Please upload the below to the above application.

- Possible parking option 2a – it could be challenging to manoeuvre into the parallel spaces entirely within red edge and may require use of neighbouring land
- Just a note – parking spaces need to meet 2.4m by 4.8m and do not need to be 3m by 6m (this is for garages) –although of course access to the retail unit should be clear
- Subject to formal consultation and considering that no increase in commercial floor space and small scale of residential development, I do not think LHA could cite highway safety reasons to object based on nil car parking (especially considering parking survey indicates on street parking available in vicinity)

As agent of the above planning application I have just become aware of a couple of emails that have posted online on Arun DCs website in relation to the use and ownership of the forecourt at 107 Felpham Way.

Drg.No.HOP-002-P. Rev F

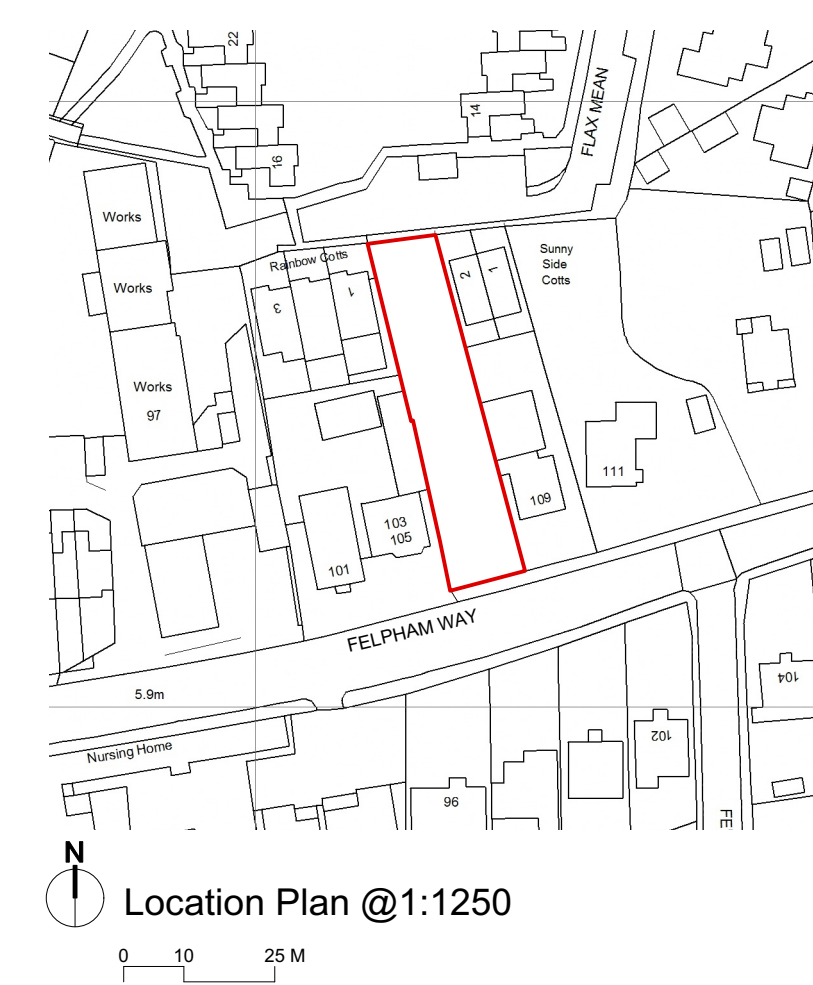
Obviously when submitting the application the applicant was under the impression that the forecourt could be used for parking. In response to Katie's consultation response of the 28th January 2020 I sent two indicative parking layouts (attached) to Maria Tomalova at Arun DC. These sought to respond to Katie's comments by relocating the proposed secure cycle store (to an area to the east of the existing building) and setting the parking spaces back to allow for the retention of the existing access ramp and steps which are in front of the shopfront. I had also hoped to be able to demonstrate that it was possible to achieve either 2 or 3 vehicle parking spaces (6m x 3m) within the forecourt – the 2 spaces would utilise the existing dropped kerb, the 3 spaces would require a dropped kerb to be provided across the front of the site. I had hoped to seek Katie's advice on which of the two layouts was feasible before asking our architect to formally revise the submitted drawings.

Katie, please could you advise me as to whether you would object to this application if no vehicle parking was to provided within the site for this development? If the HA does not object then I will ask the schemes architect to revise the submitted layout drawing to indicate the forecourt as land to be retained as open forecourt – with the area hatched to show no parking.
